South Downs National Park Authority

Principal Areas of Disagreement Summary Statement - Final Issue

29 July 2024

Table 1 – Outstanding Principal Areas of Disagreement

Key

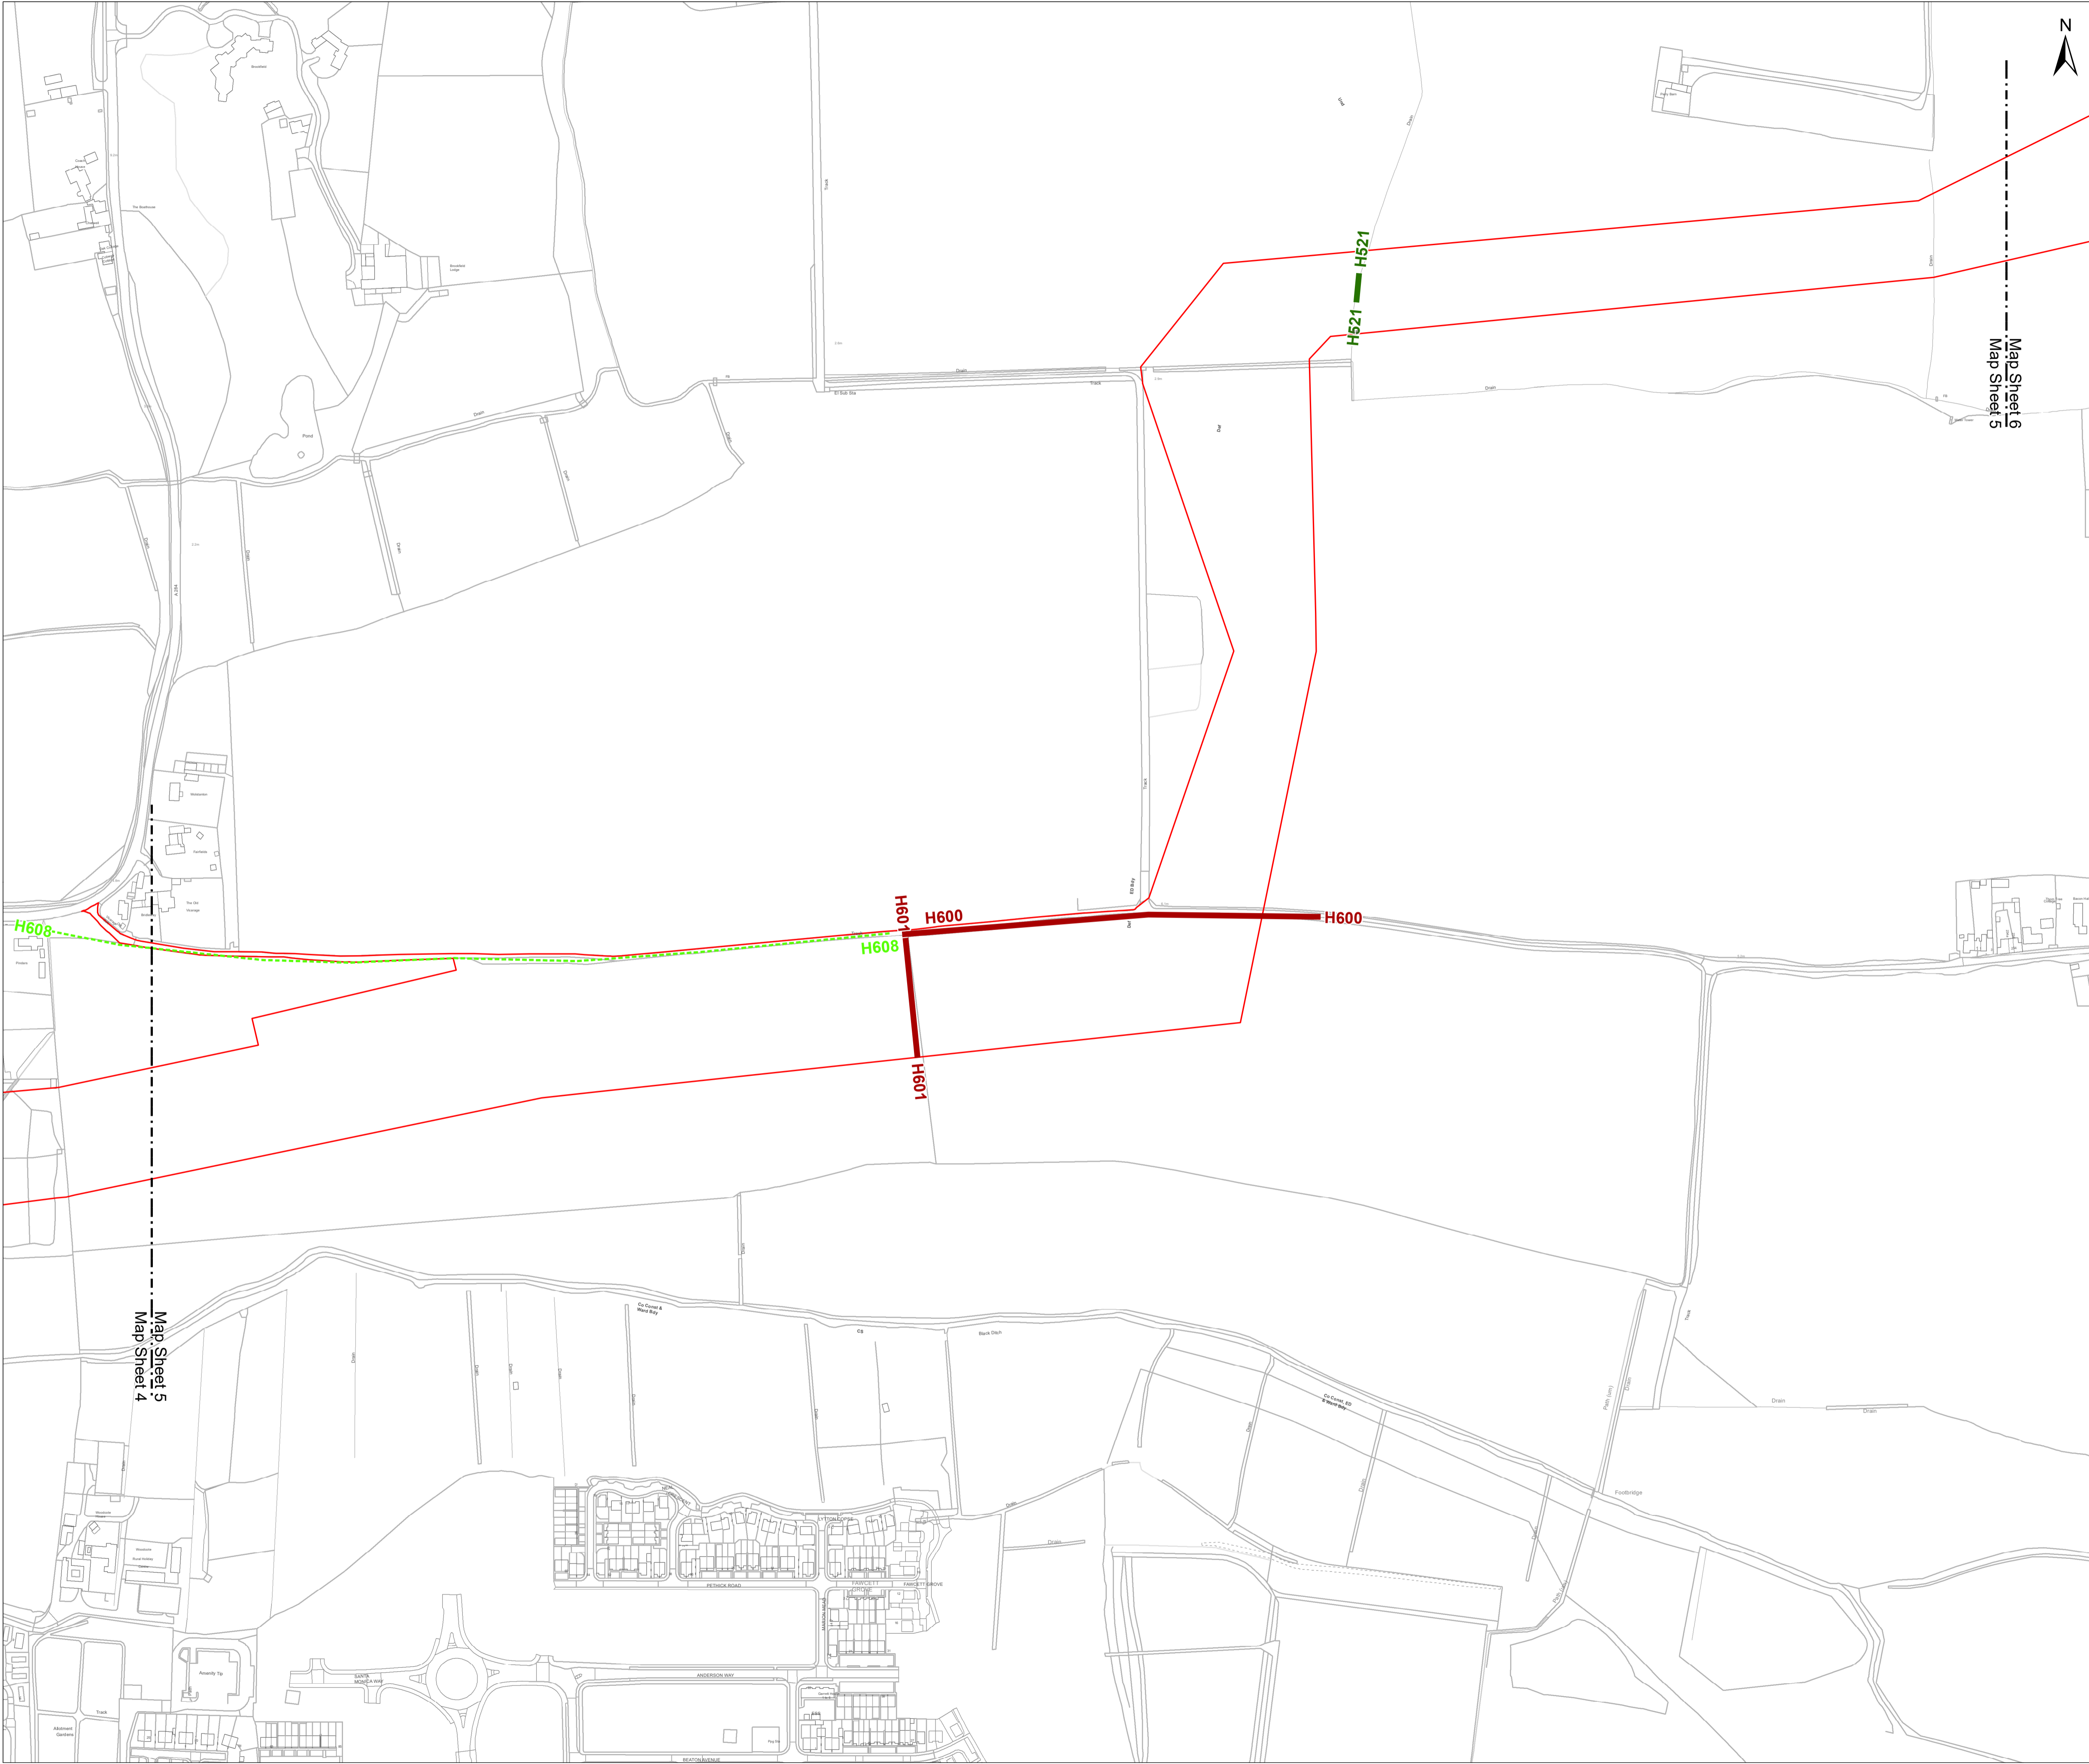
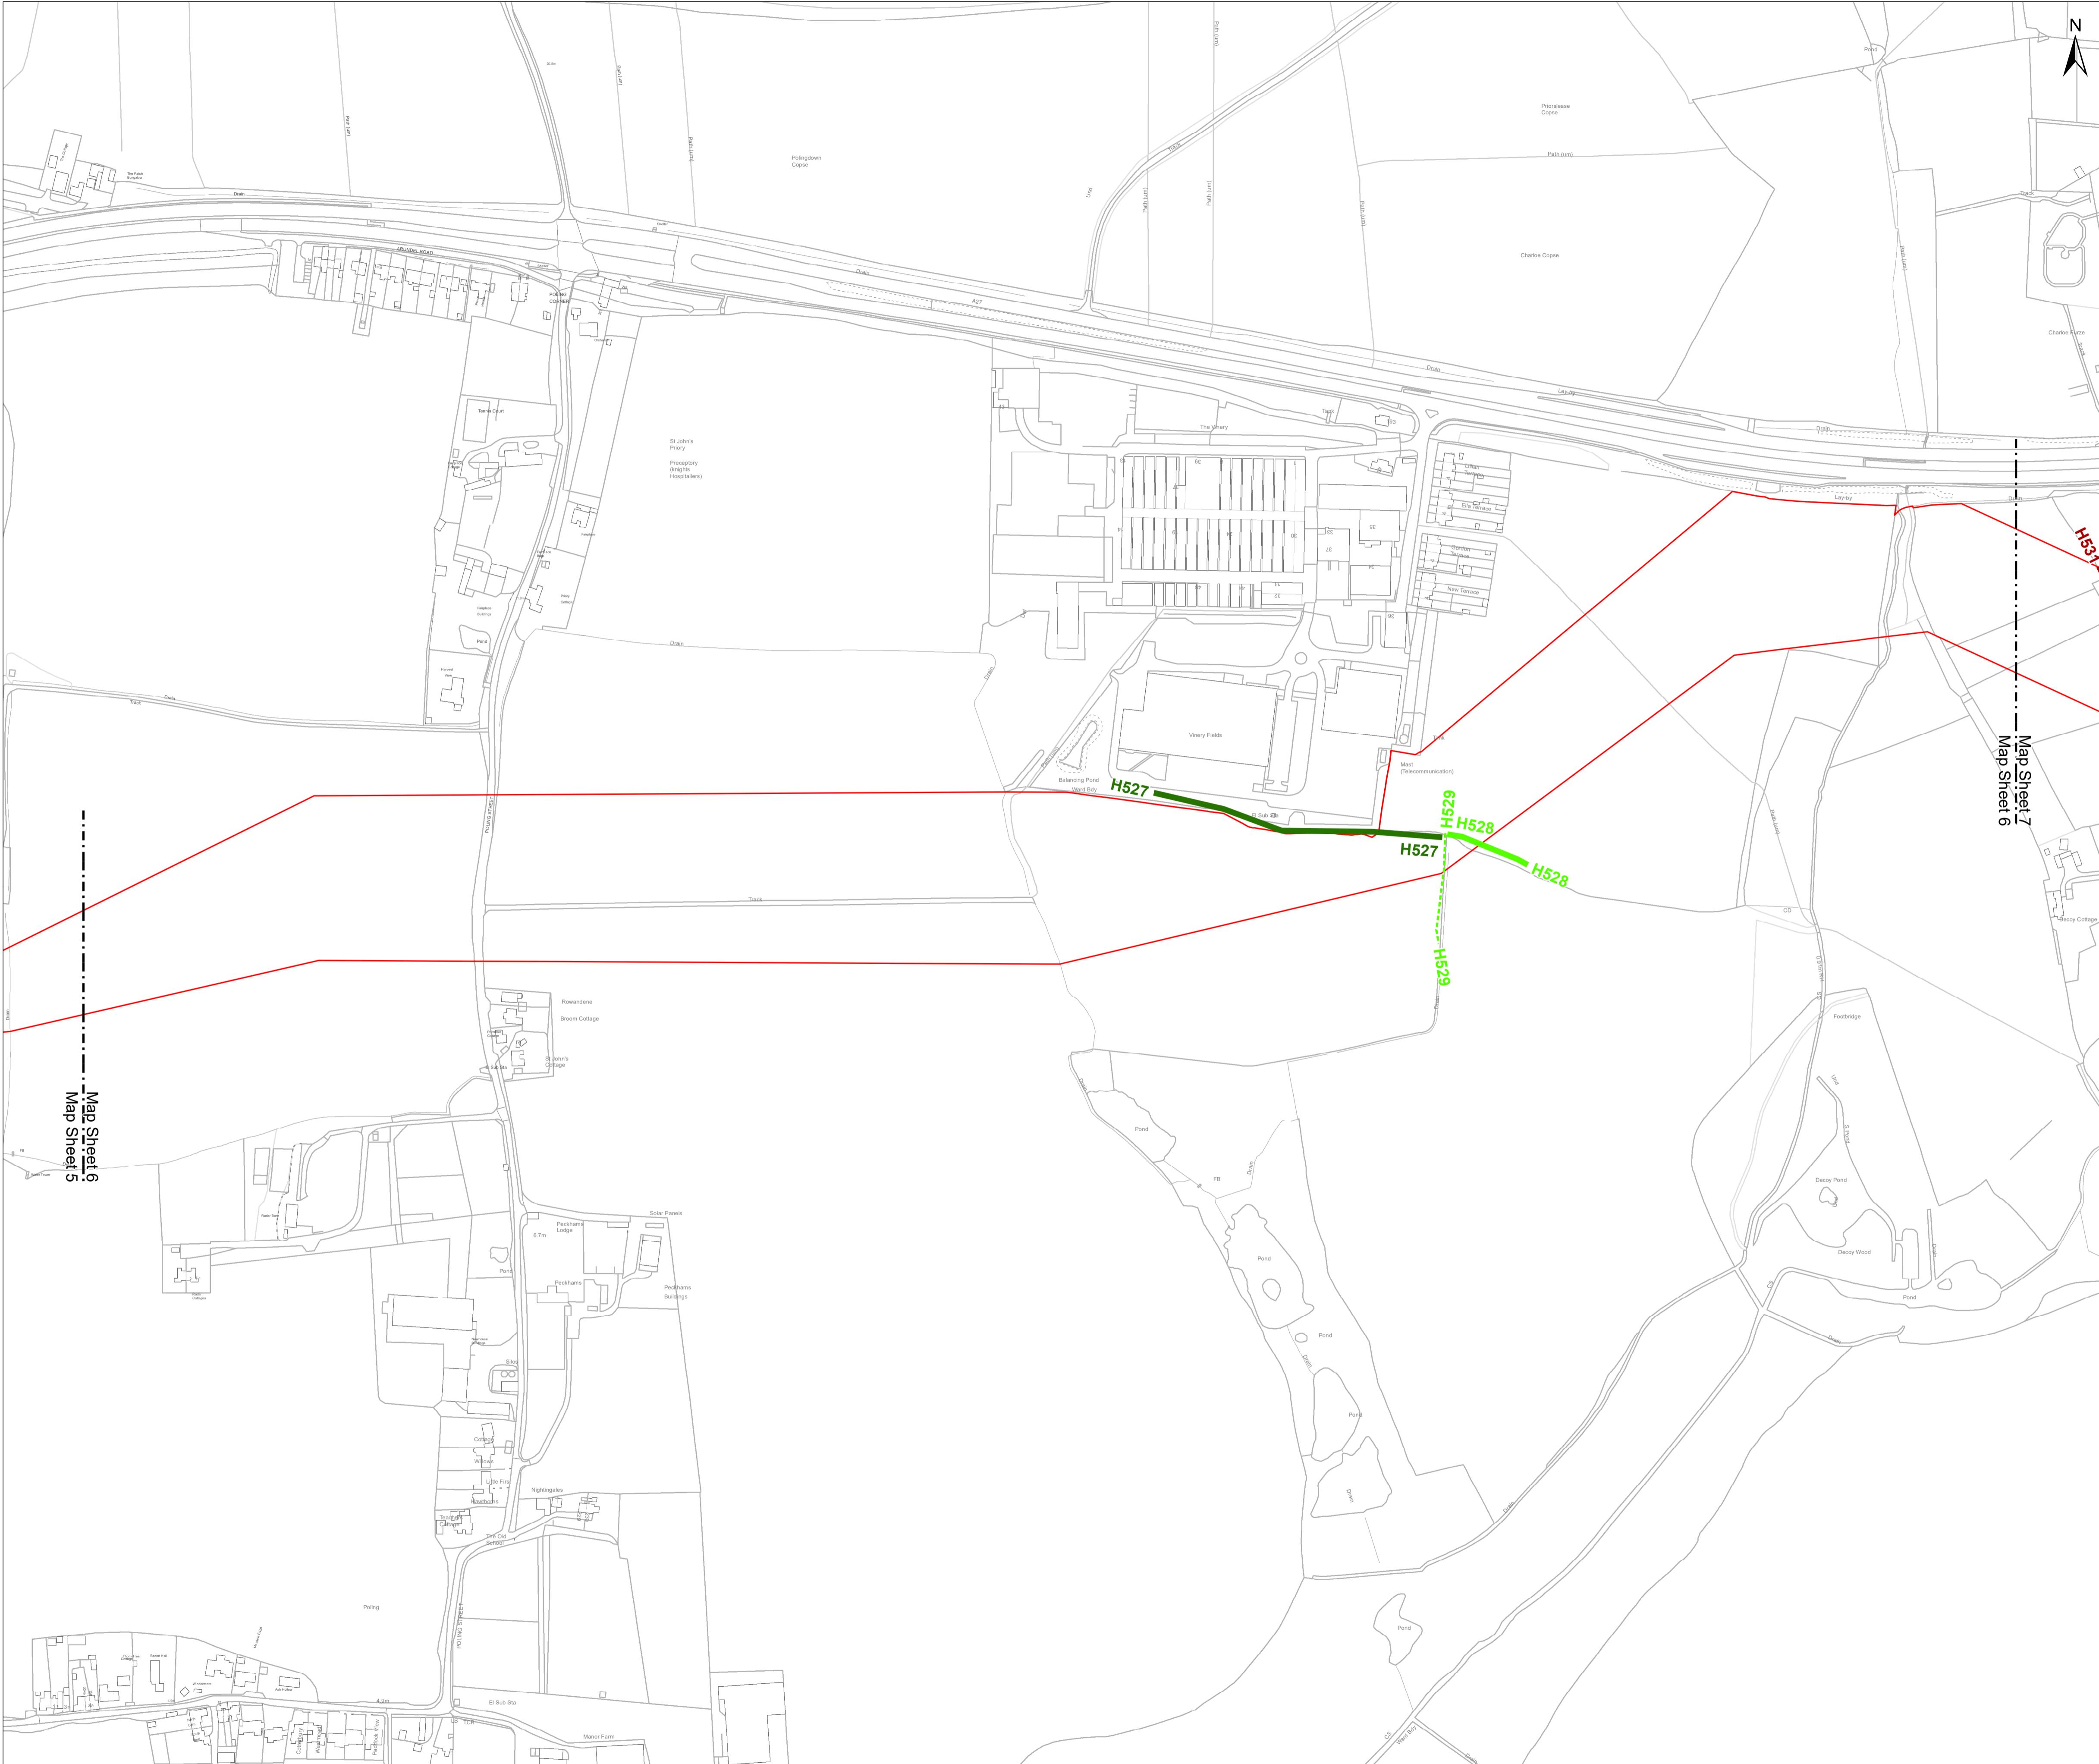
SDA-15	Loss of key Landscape Features	<p>Significant concerns over likely success of proposed hedge notching. The examples cited for use of the technique in the Lake District and Norfolk Broads are not likely to have encountered the challenges of dry, free draining chalk soils. No proven testing undertaken to evidence proposals. If this would not work, the landscape, ecological and visual impact would be significant.</p> <p>Clarity required to explain why 6m width notching technique cannot be used for all hedges regardless of importance.</p>	<p>Applicant to provide further evidence on achievability on shallow chalk soils in Southern England.</p> <p>Applicant to provide further evidence on reasoning.</p>	<p>SDNPA are still not satisfied the proposed hedge notching will be successful in these landscape conditions. Further to this, it will not be possible to reinstate tree belts or mature trees in hedgerow, which are intrinsic features of this landscape. The effects are therefore far greater than the applicant has concluded.</p>
